**Transport
for NSW**

Exhibition of Environmental Assessment for a Project Application at the Former Rachel Forster Hospital site, 134-144 Pitt Street, Redfern (MP09_0068)

Transport for NSW (TfNSW) would like to provide the following comments in relation to the Environmental Assessment for the above project.

2 EAST ELEVATION BUILDINGS 1, 2 & 3 (PITT STREET VIEW)
SCALE 1:200

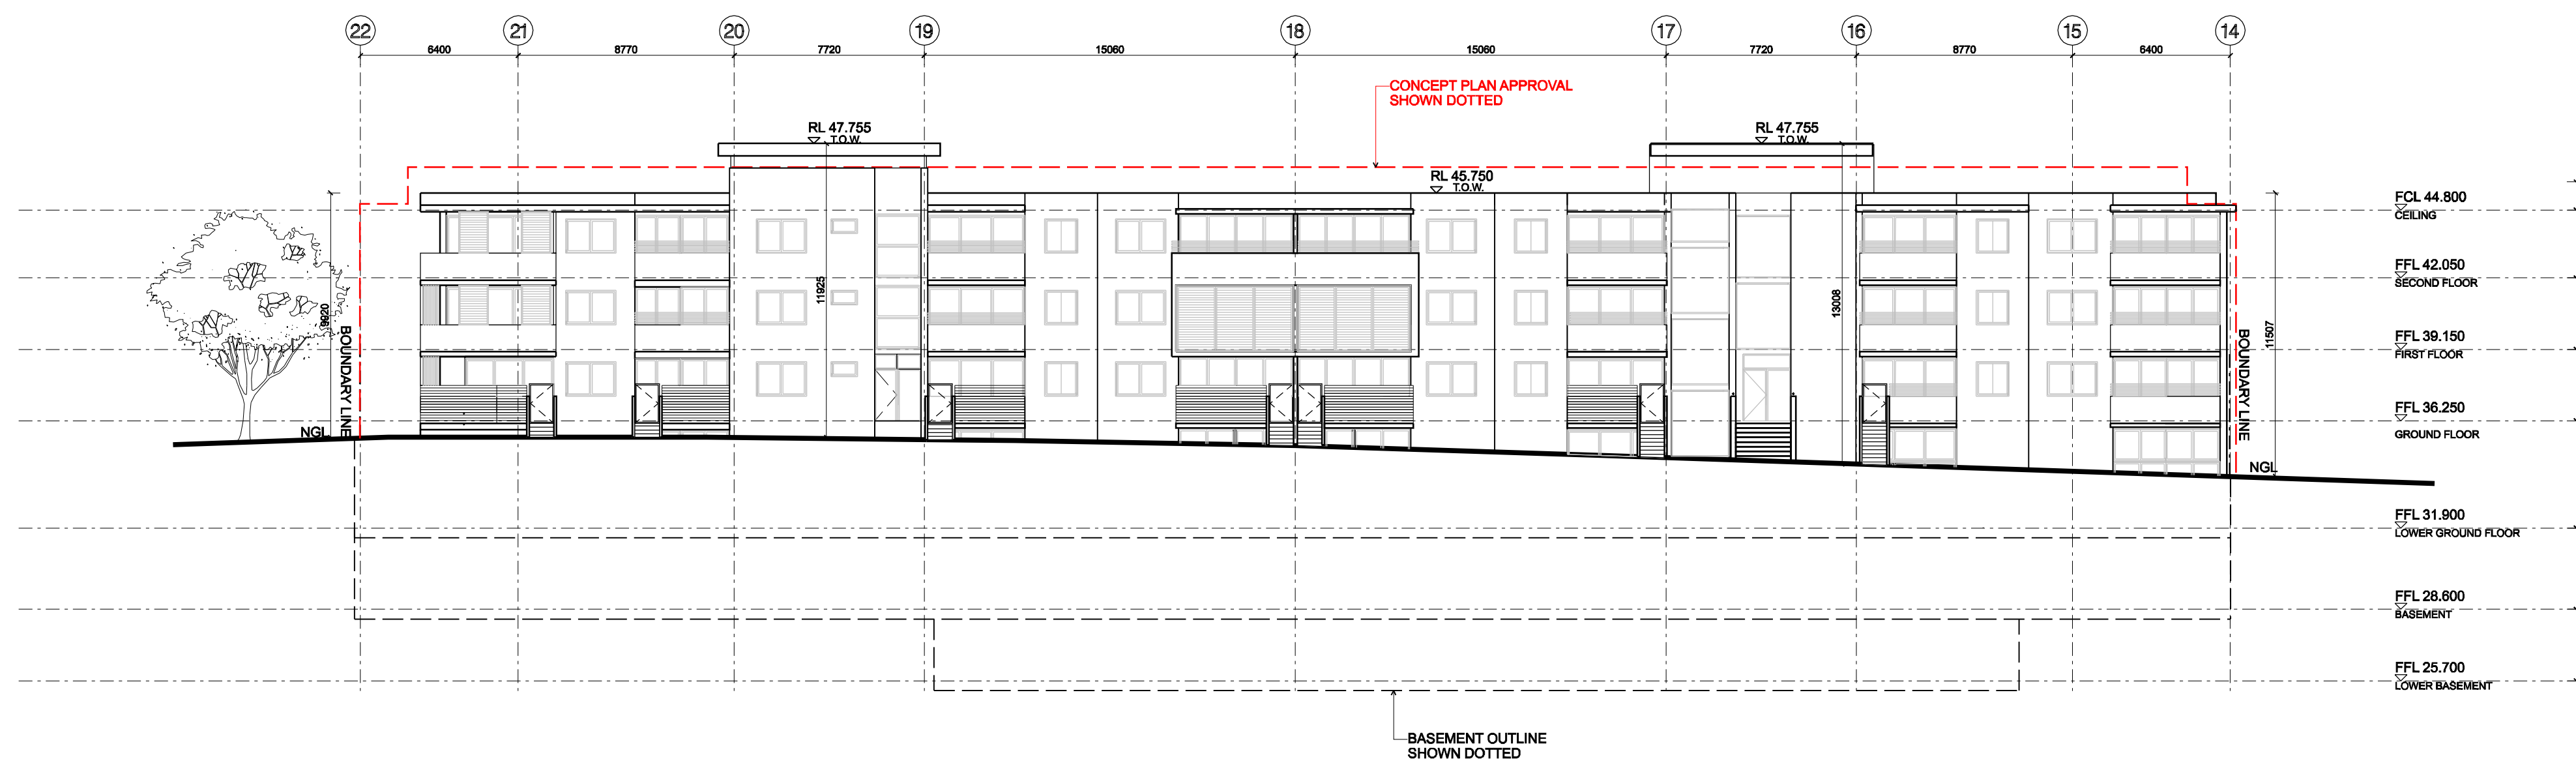
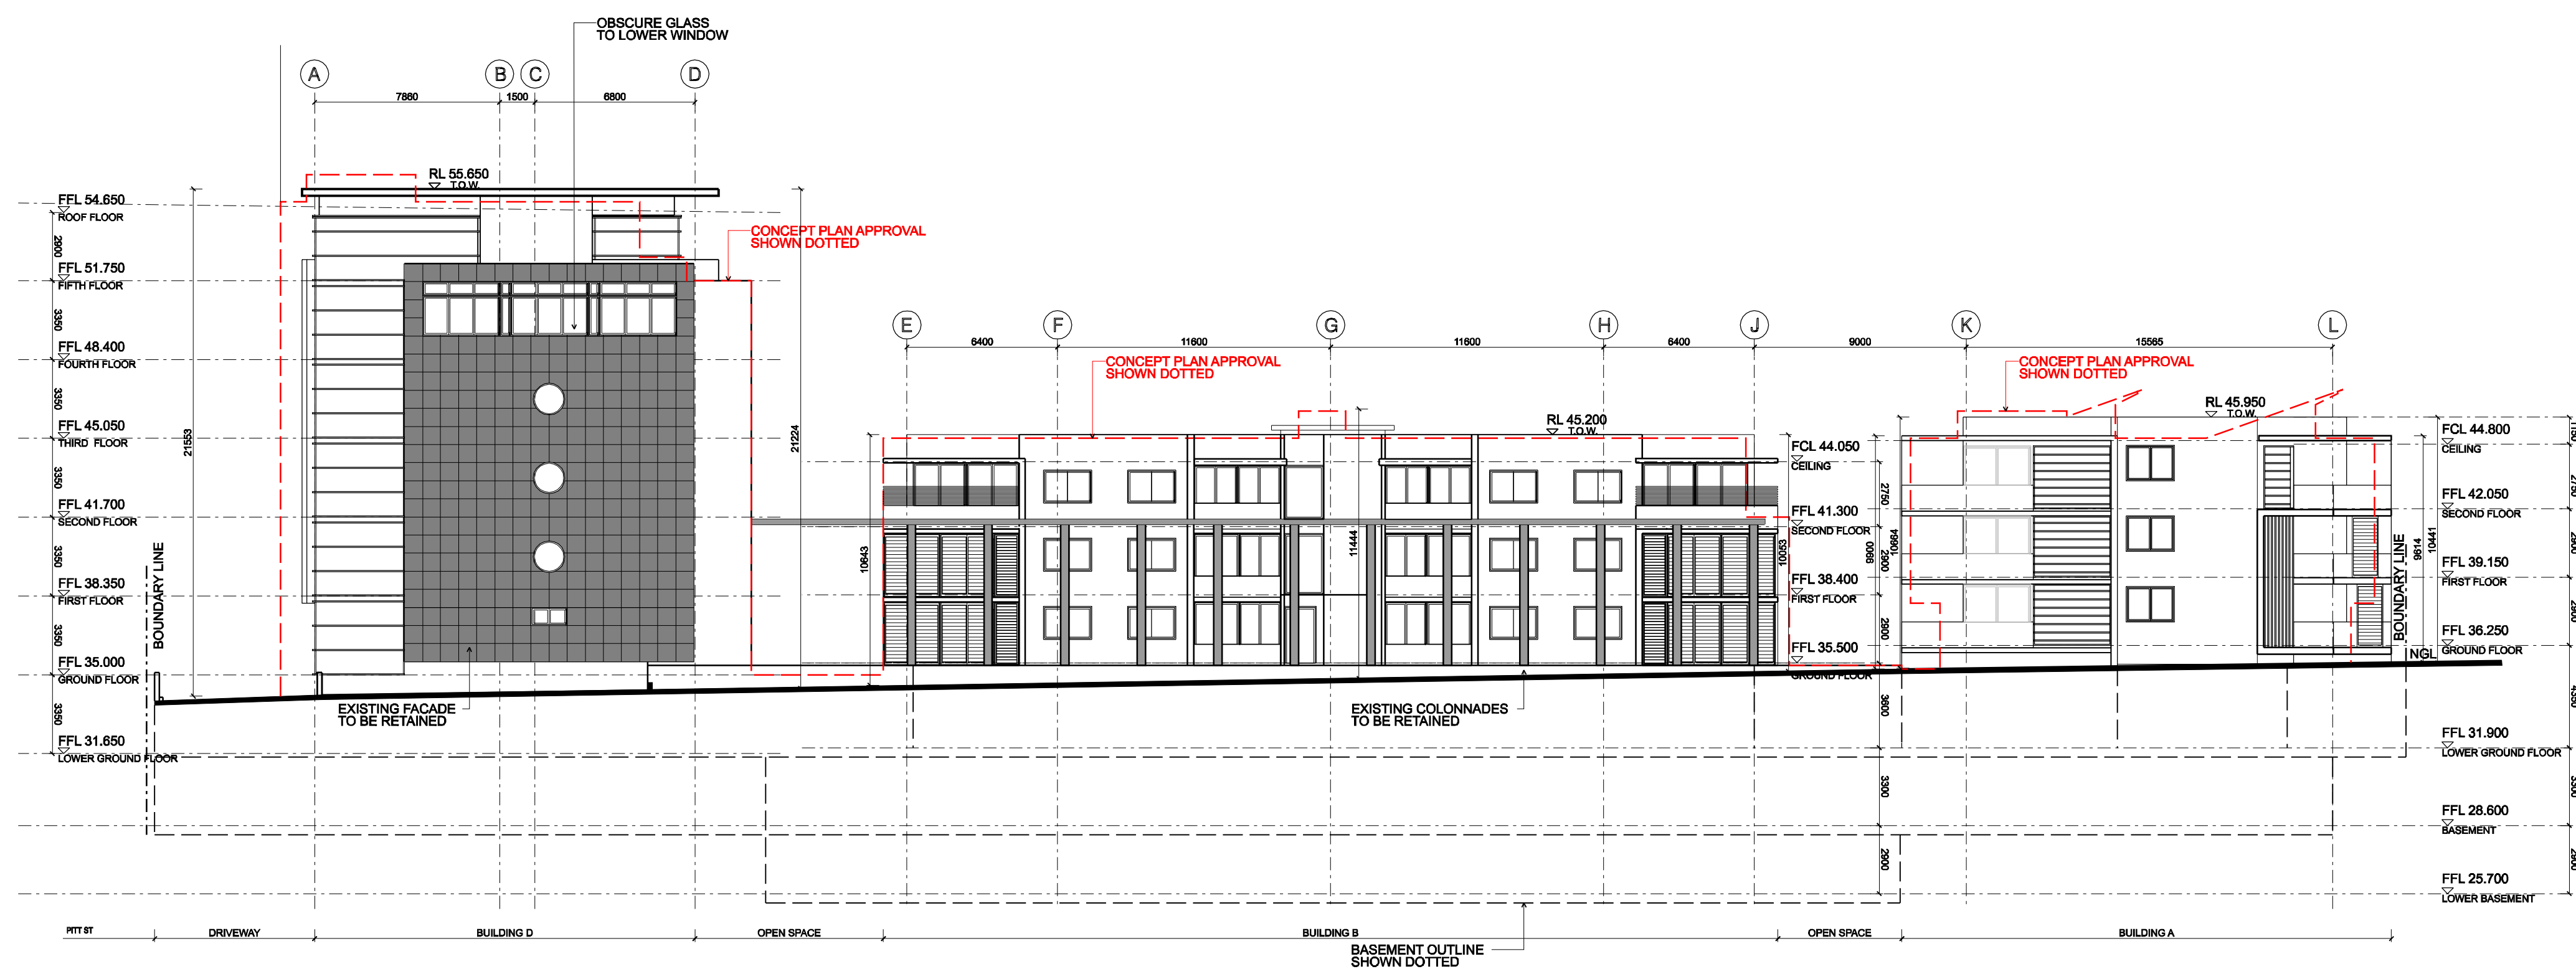
TfNSW requests the applicant should be required to upgrade the pedestrian footpaths fronting the site on Albert and Pitt Streets to improve pedestrian safety. Additionally, the applicant should be required to install adequate pedestrian access to and from the site to Redfern Railway Station and bus services on Redfern Street.
